Your Ref: OWPC21032
Our Ref: WA/113/18/HH 27-12-2018
Please ask for:
Amber Willard

Two storey rear extension, first floor side extension and conversion of garage to habitable use.

9 Orchard Way Fontwell Walberton

Proposed Roof Plan

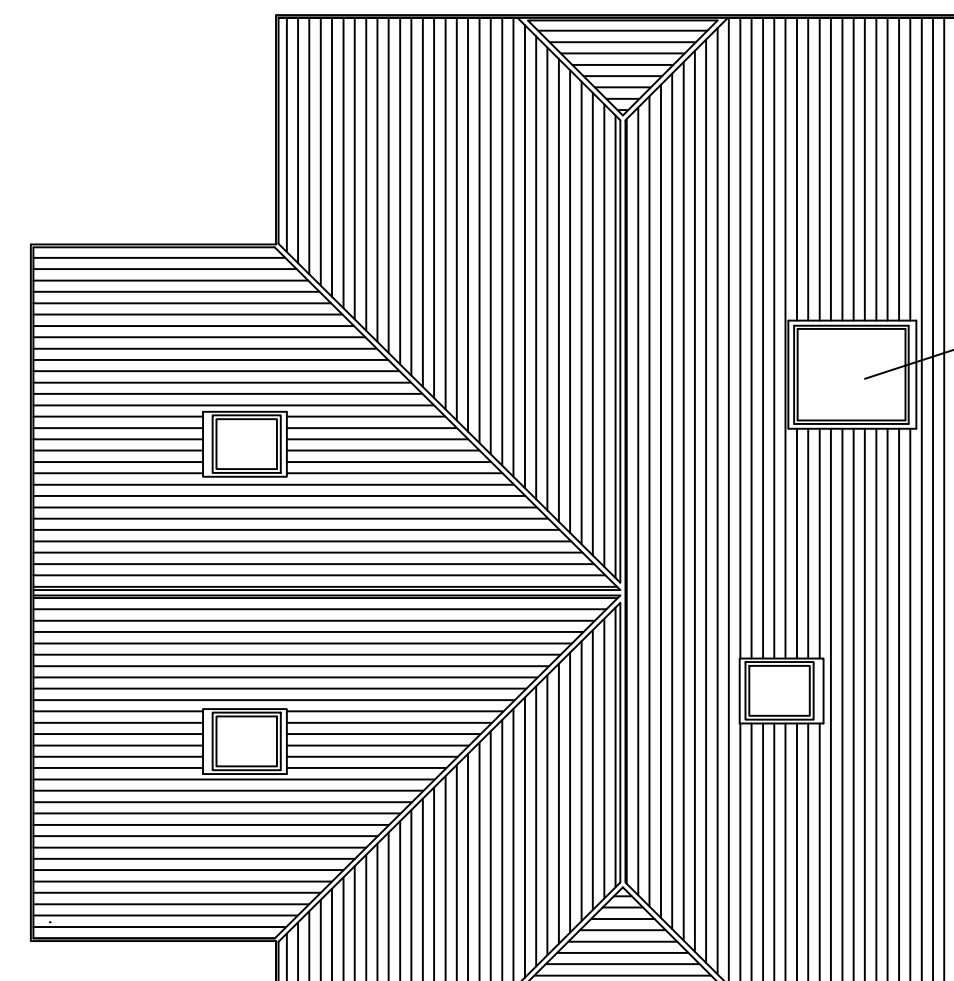
If the existing glass to the new velux window in the east elevation is changed to obscure then we have no objection , good to see that the new back door is being changed to a high level window.as long as these amendments are carried out sooner rather than later we have no objections to the new drawings.
